# Heckington Fen Solar Park

EN010123

## Applicant Response to the Examining Authority's First Written Questions

Document Reference: ExA.ResponseFWQ-D2.V1

Drawing file: EN010123 / EN010123-000802-ExA.SP-D2.V1- Supplementary Plan - Individual sheets showing isolated work areas for sheets 5, 6, 12,13 of Works Plan - Rev 1.pdf

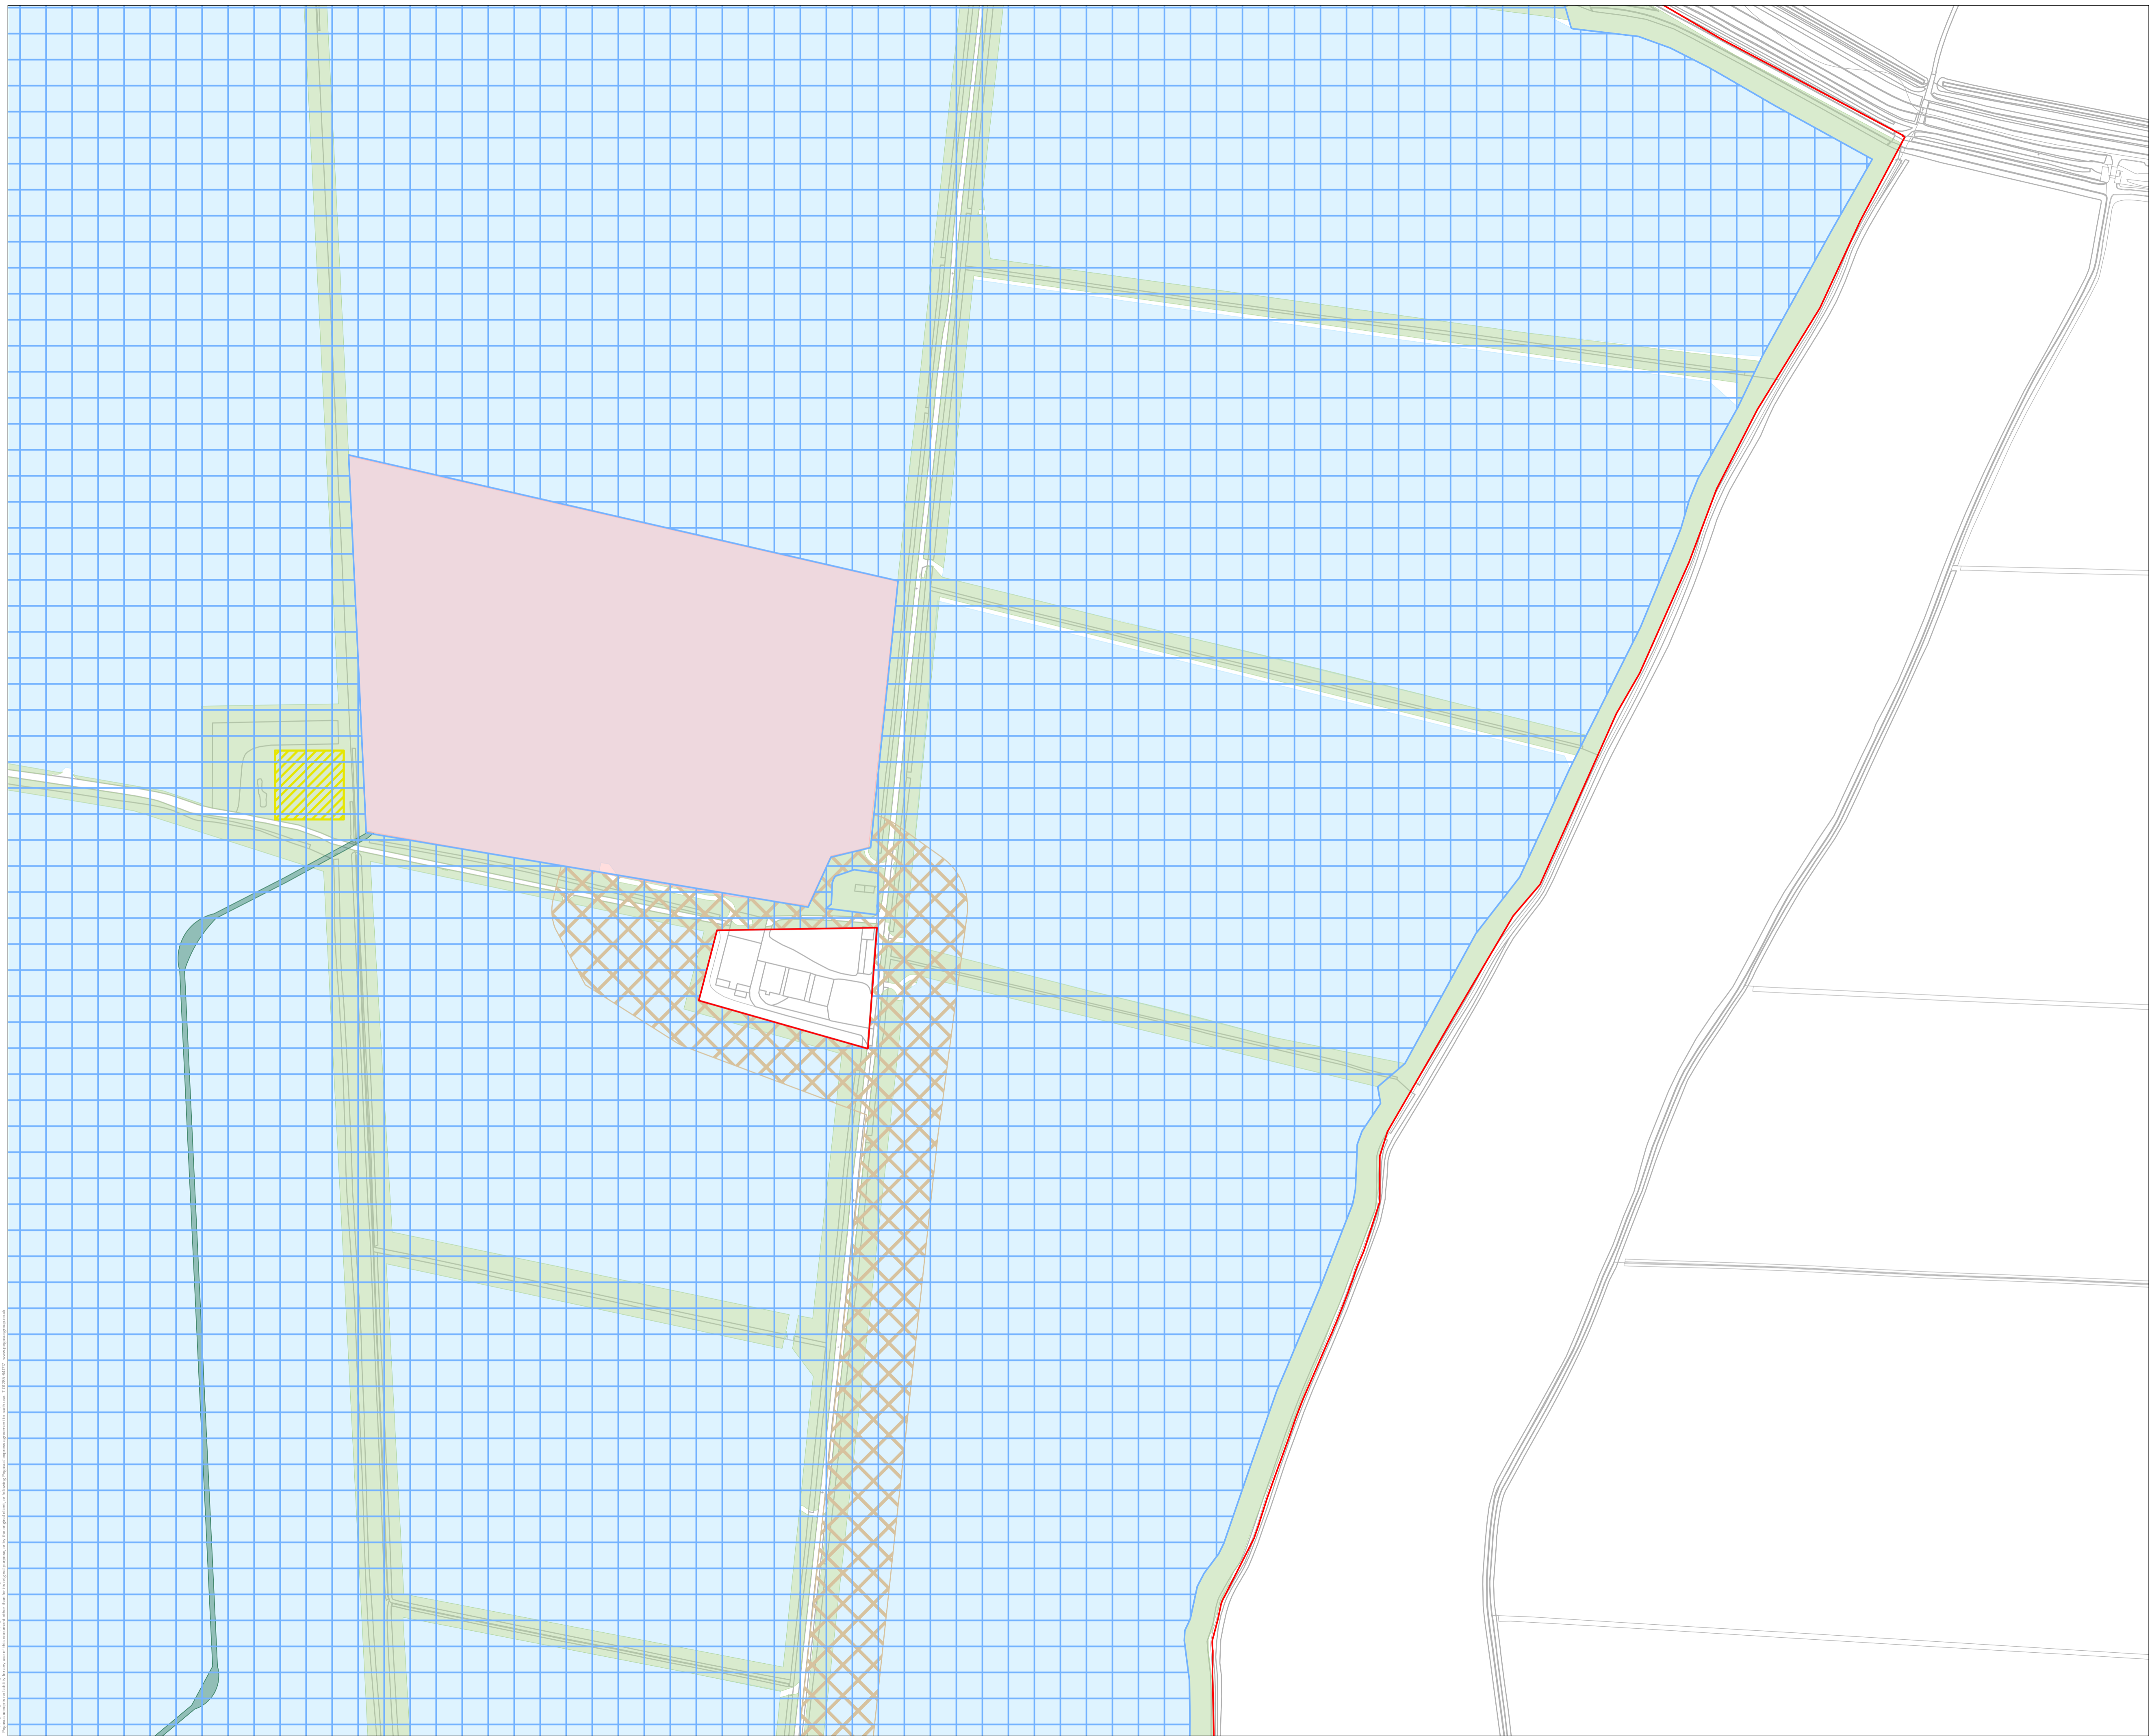
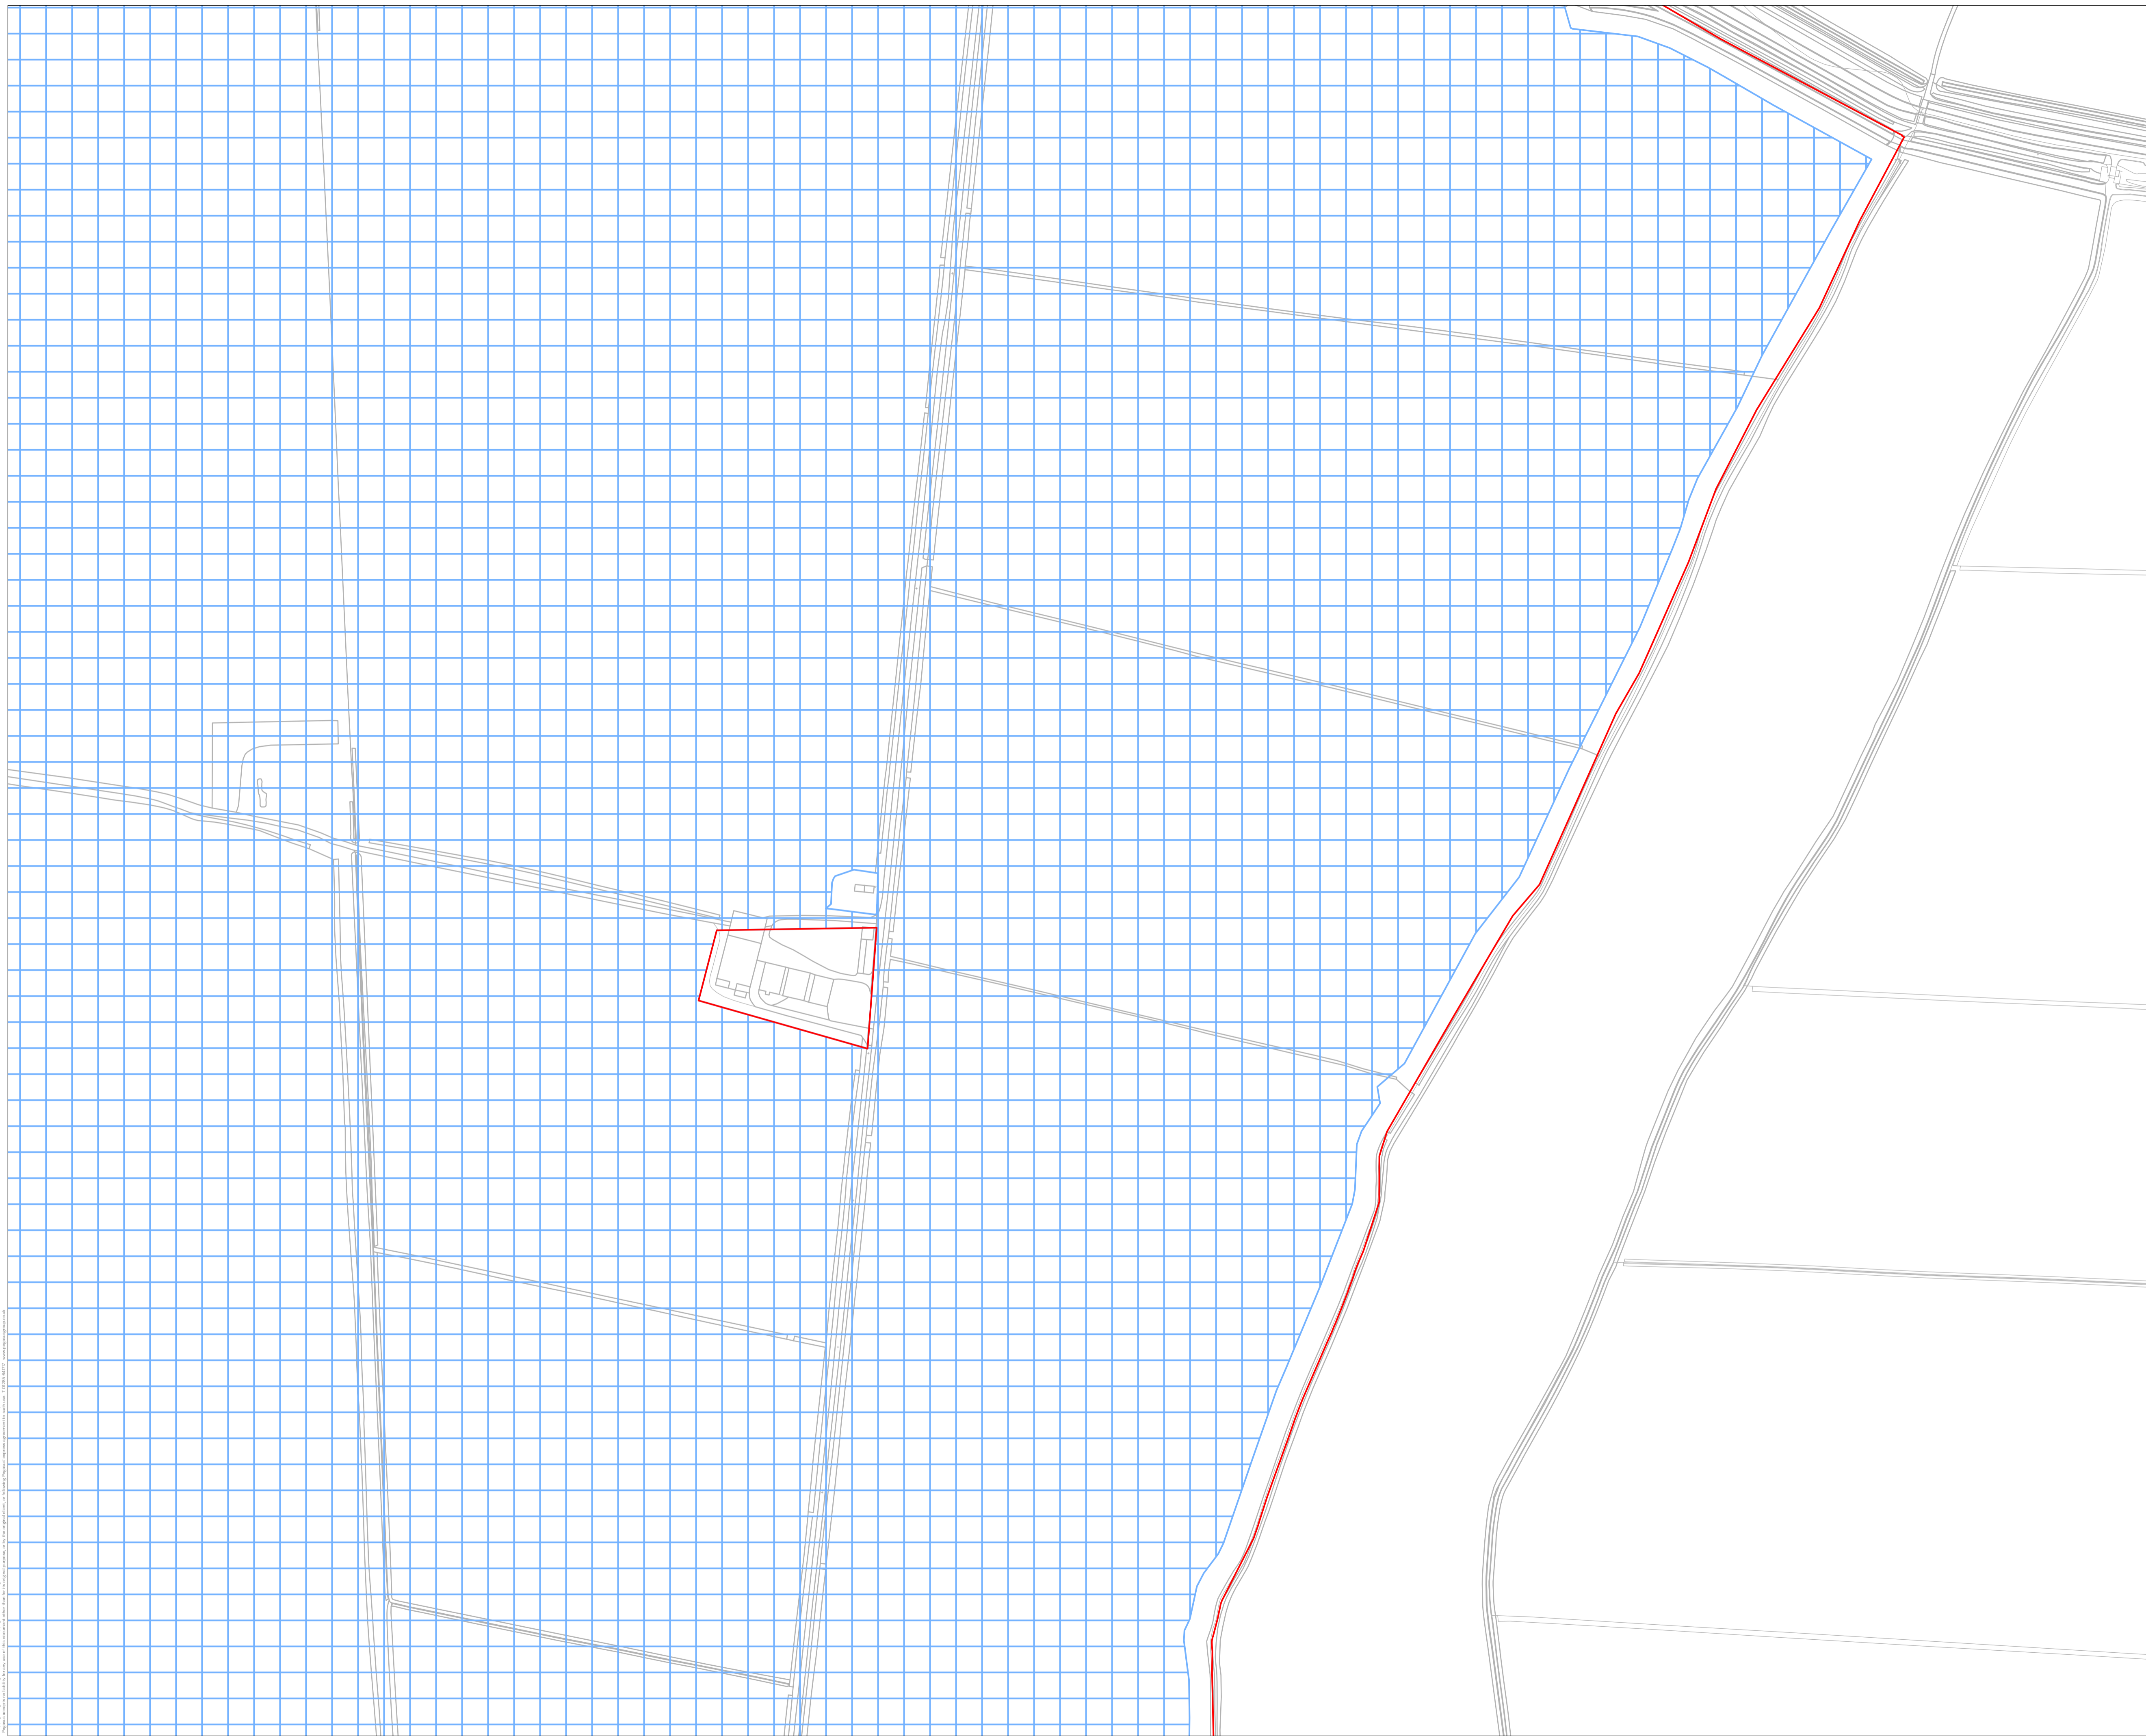
ExA Question Number:	Question Addressed to:	Question	Applicant's Response
GEN 1.1	The Applicant	<p>Sheets 5, 6, 12 and 13 of the Works Plans [PS-014] show numerous overlapping Works No's around the on-site substation and the Bicker Fen substation. Due to the scale of the plans and the overlapping colours/patterns the exact boundaries of many of the Work No's in these areas of the Proposed Development are ambiguous.</p> <p>Provide individual plans to clearly show the extent of each of the Work No's in these areas. These should not supersede the Works Plans but would be supplementary to them.</p>	<p>The Applicant has prepared a supplementary plan with individual sheets for each of the work layers shown on sheets 5, 6, 12, and 13 of the Works Plan. The Applicant has included this standalone document with the Deadline 2 submissions- <b>Supplementary Plan: Individual sheets showing isolated work areas for sheets 5, 6, 12, and 13 of the Works Plans</b> (document reference: ExA.SP-D2.V1).</p> <p>In respect of the <b>Works Plans</b> (document reference 2.2/PS-014), the Applicant has reviewed its approach to showing an illustrative layout of the substation and energy storage within the pink area on sheet 5 of the Works Plans. The Applicant previously considered that it may be helpful for stakeholders to see an indicative layout of how the infrastructure may be configured at the Energy Park. However, following further review (including alongside other DCO projects such as the recently consented Longfield Solar Farm Order), the Applicant has decided to remove the indicative infrastructure from sheet 5. This is because each numbered work must be situated within the corresponding numbered area shown on the works plan (pursuant to Article 3(2) of the DCO) and, as the Applicant outlines in paragraph 2.1.22 - 2.1.26 of the <b>Explanatory Memorandum</b> (document reference 3.3), the Applicant has adopted a Rochdale Envelope approach and assessed worst case parameters across this area. This means that the energy storage and onsite substation could be anywhere within this pink area on sheet 5. It could therefore be confusing or misleading to include an indicative layout at this stage of the process. Accordingly, the Applicant has removed this indicative infrastructure 'layering' from the Works Plans and updated accordingly in Revision 4 of the Works Plan submitted at Deadline 2. However, the indicative drawings remain, for reference, within the Environmental Statement at <b>Figure 4.1g- Indicative Energy Storage Arrangement</b> (document reference 6.2.4 / APP-108).</p>
